TOWN AND COUNTRY PLANNING ACT 1990 FULL

Reference: H09-0544-25 **Date of Decision:** 29th July 2025
Applicant: Mr & Mrs M Clark
Fair View
Holbeach Drove Gate
Holbeach Drove
Spalding
PE12 0PX
Location: Fair View Holbeach Drove Gate Holbeach Drove Spalding
Description: Rear extension to dwelling

PROJECT NUMBER :
J25175
 DRAWING REFERENCE :
PL01

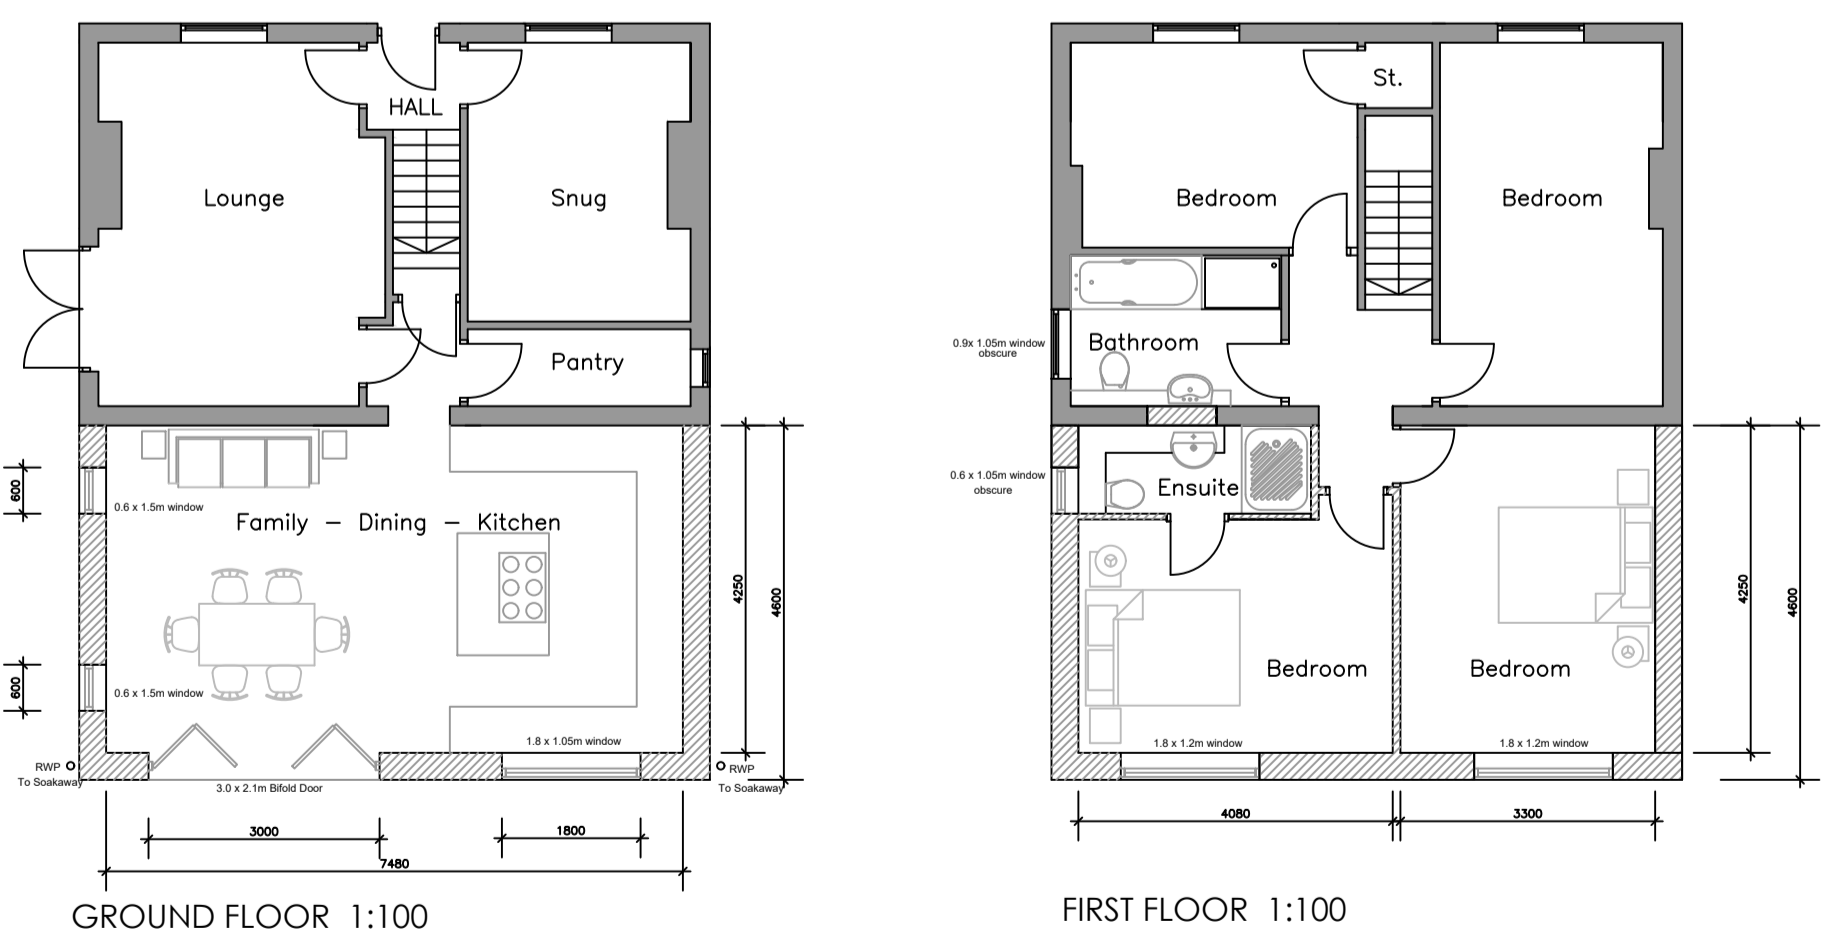
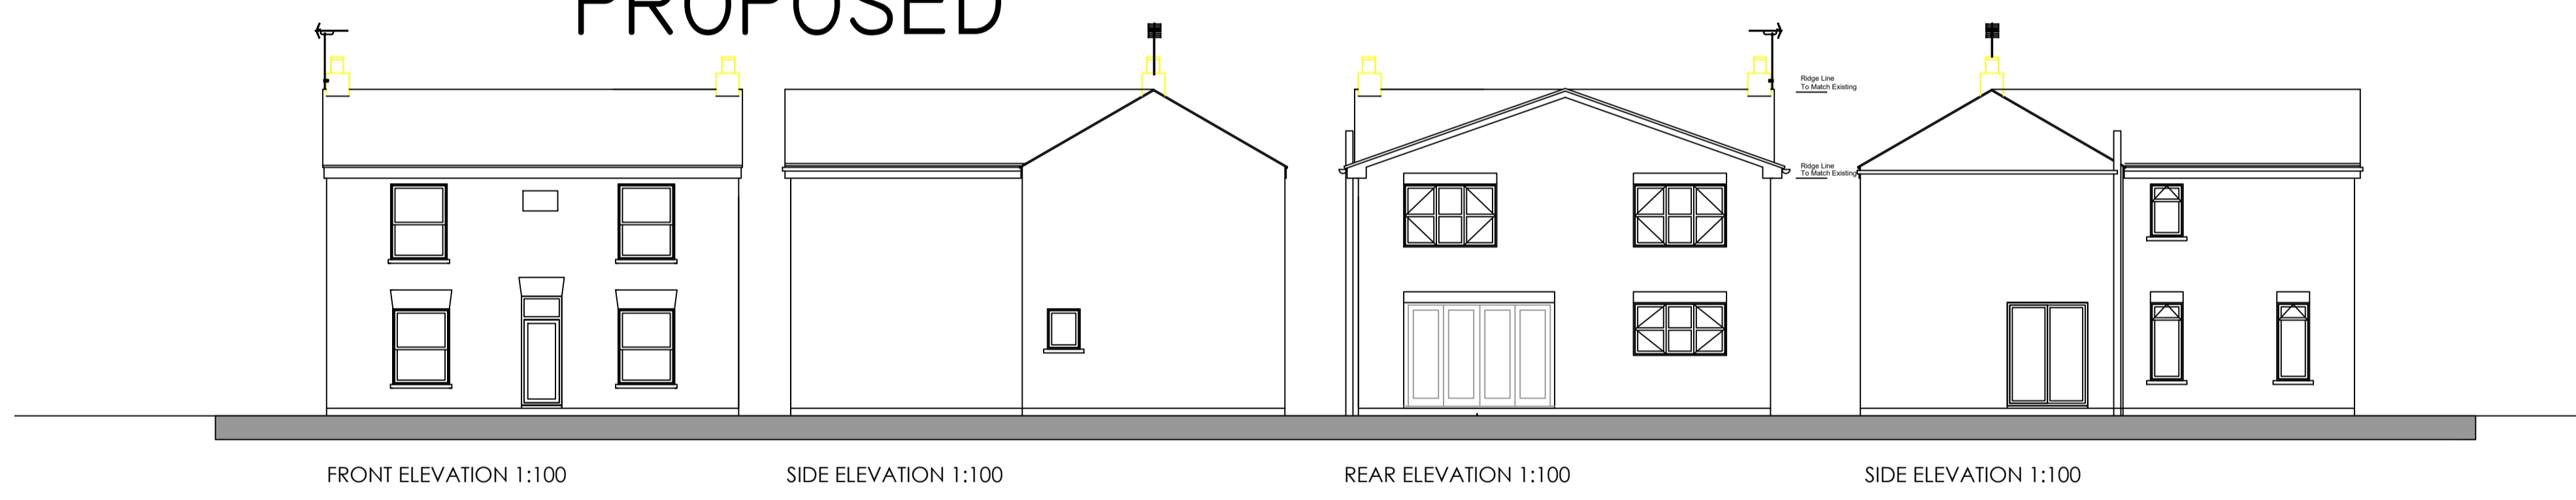
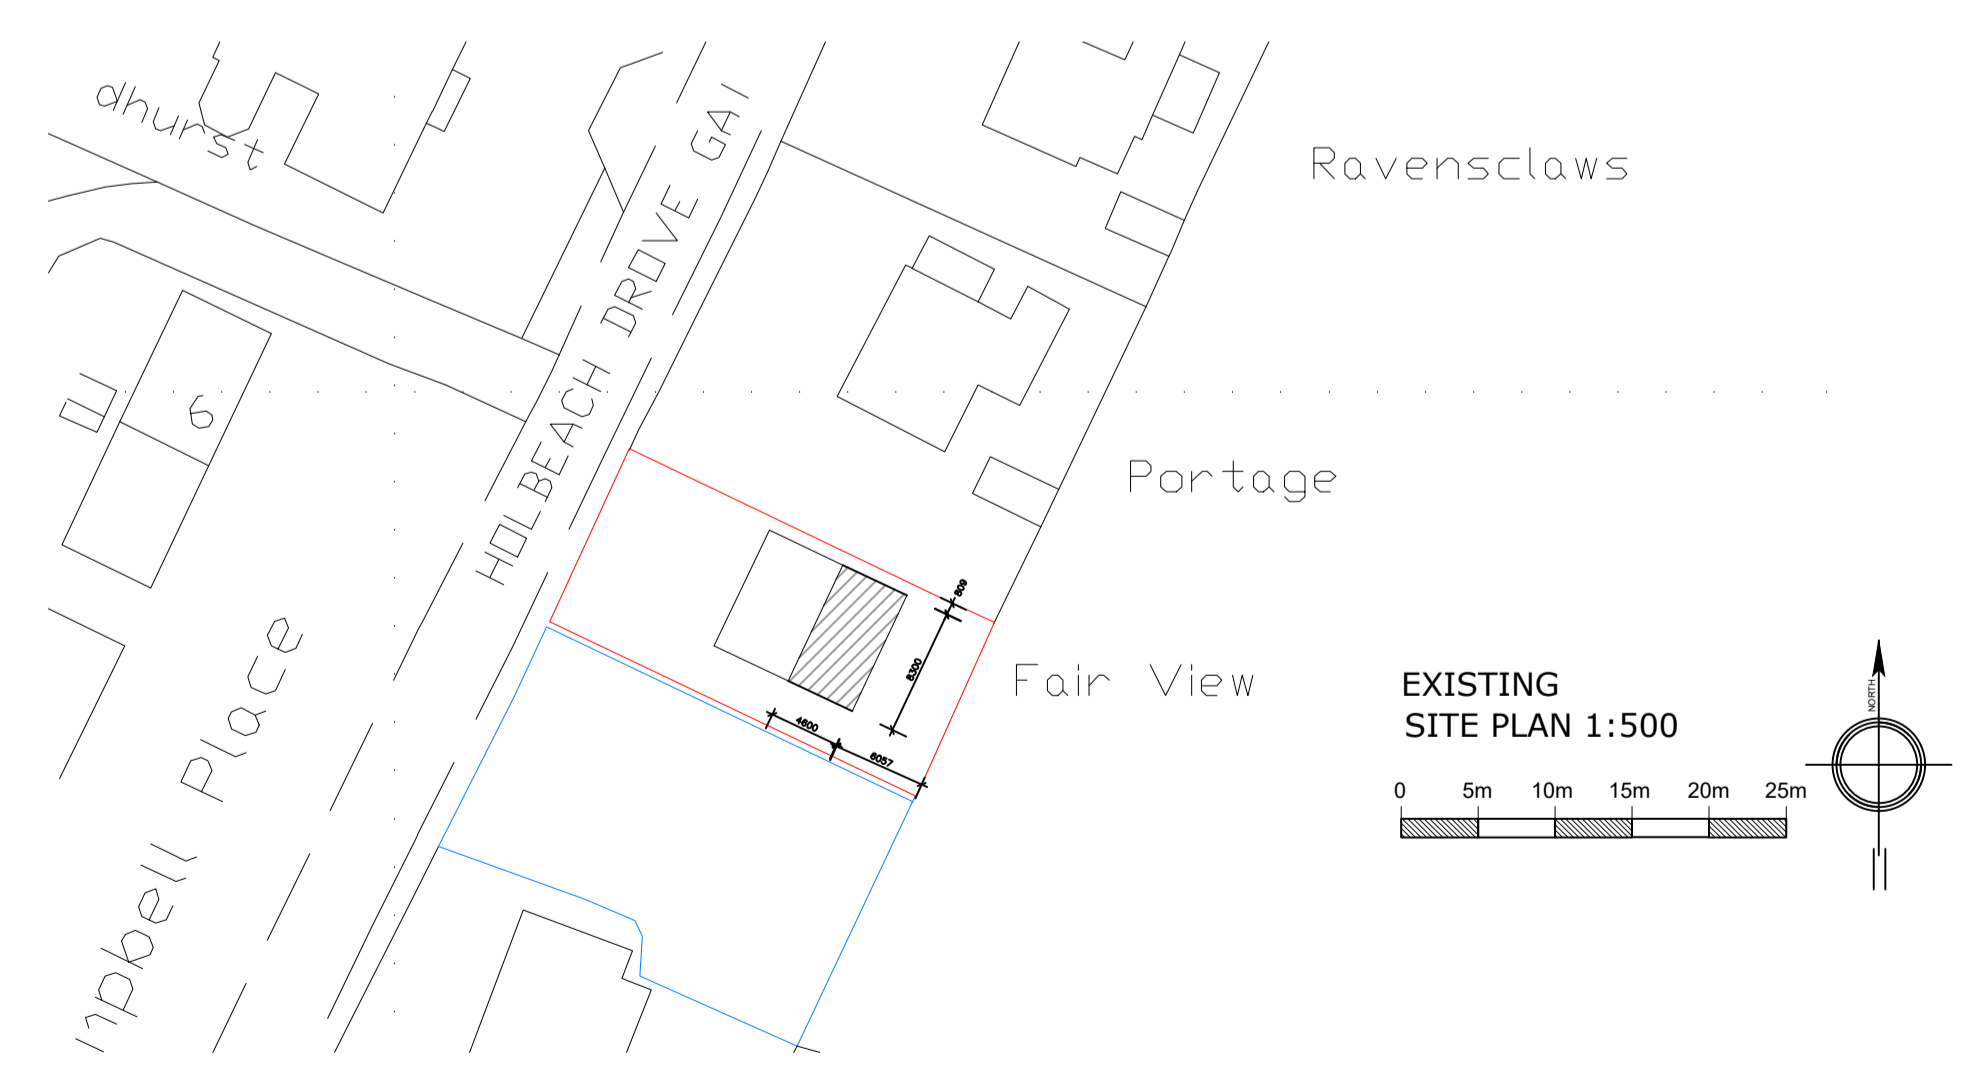
- 1 The proposed extension would comprise a disproportionate addition to the main dwelling, resulting in a visually incongruent form of development that would harm the character and appearance of the area. The scale of the development would be out of keeping with the area and appear overly dominant when compared to the host dwelling. The proposed rendered facades would exacerbate the harmful impact of the extension, as render would unduly contrast with the red brickwork on the main dwelling. The extension would not be subservient or proportionate to the host dwelling and the rendered facades would also not respond sympathetically. As such, the proposed development would have an unacceptable impact upon the character of the area and is therefore contrary to Policies 1, 2 and 3 of the the South East Lincolnshire Local Plan (2019) and Section 12 of the NPPF, specifically Paragraph 135.
